Permit Number: 041263

Condominium rental unit 40 renovation

38 Eastern Promenade

City of Portland, Maine - Building or Use Permit

Unit 40B

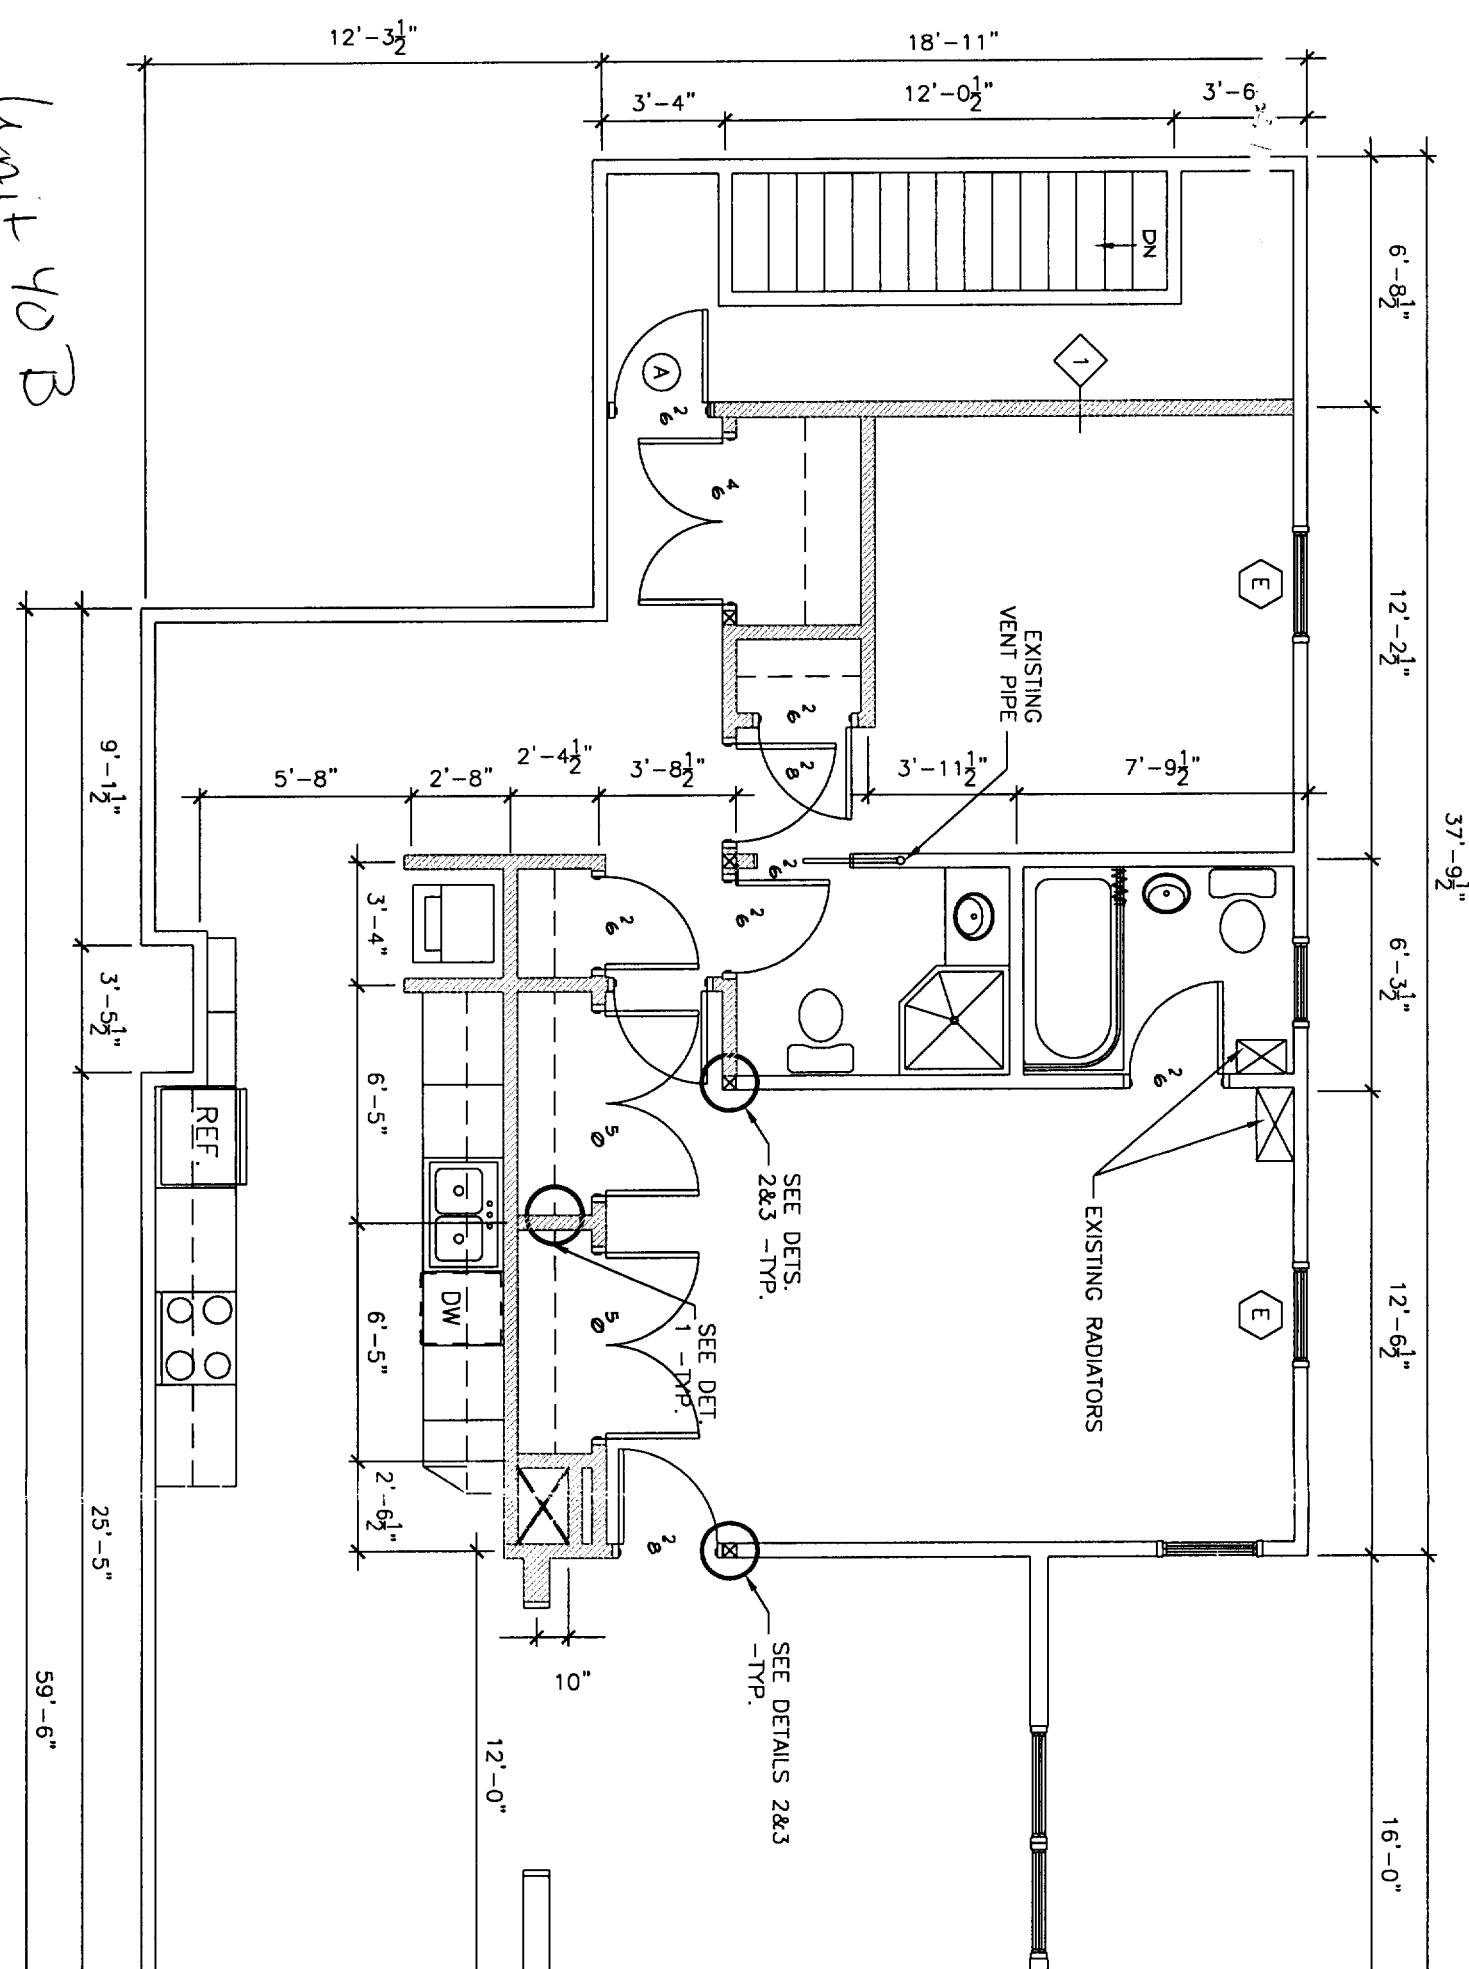
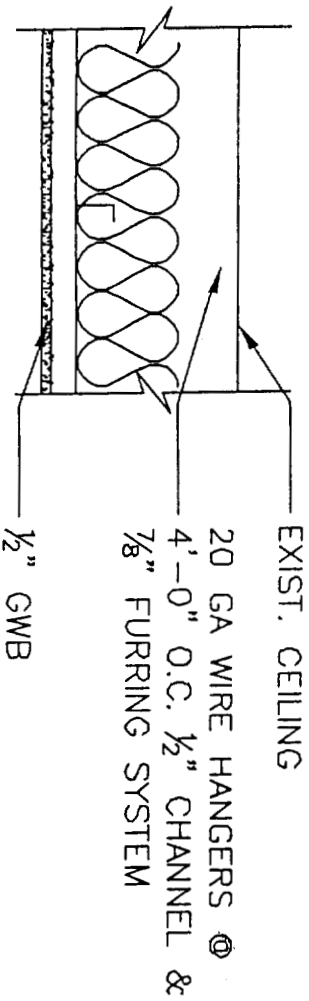
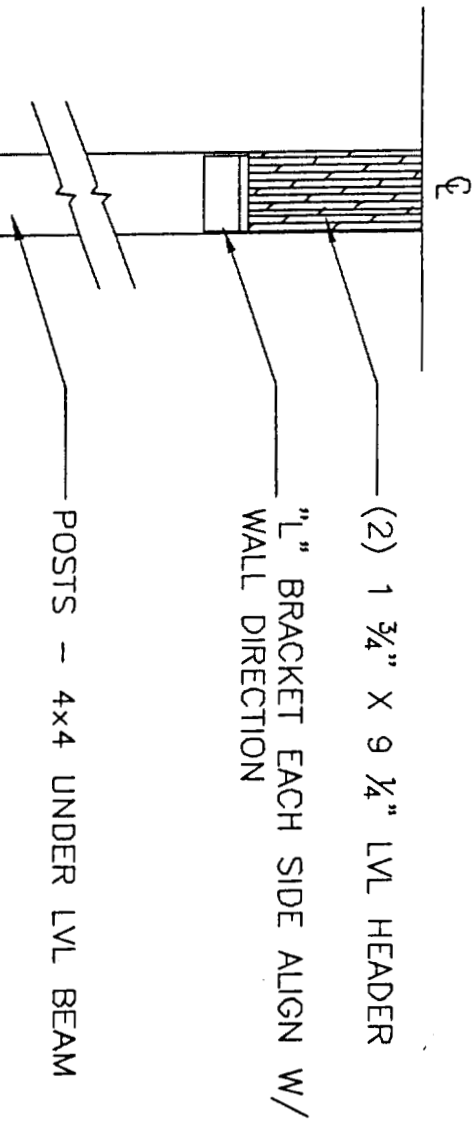
Dept: Building Status: Approved with Conditions Reviewer: Mike Nugent Approval Date: 09/14/2004 **Note:** Dwelling units must be separated with a one hour floor ceiling separation.

Dept: Fire Status: Approved with Conditions Reviewer: Lt. MacDougal Approval Date: 09/01/2004 **Note:** 1) the smoke detectors shall be installed in accordance with NFPA 101
2) the sprinkler system shall be maintained to NFPA 13 standards
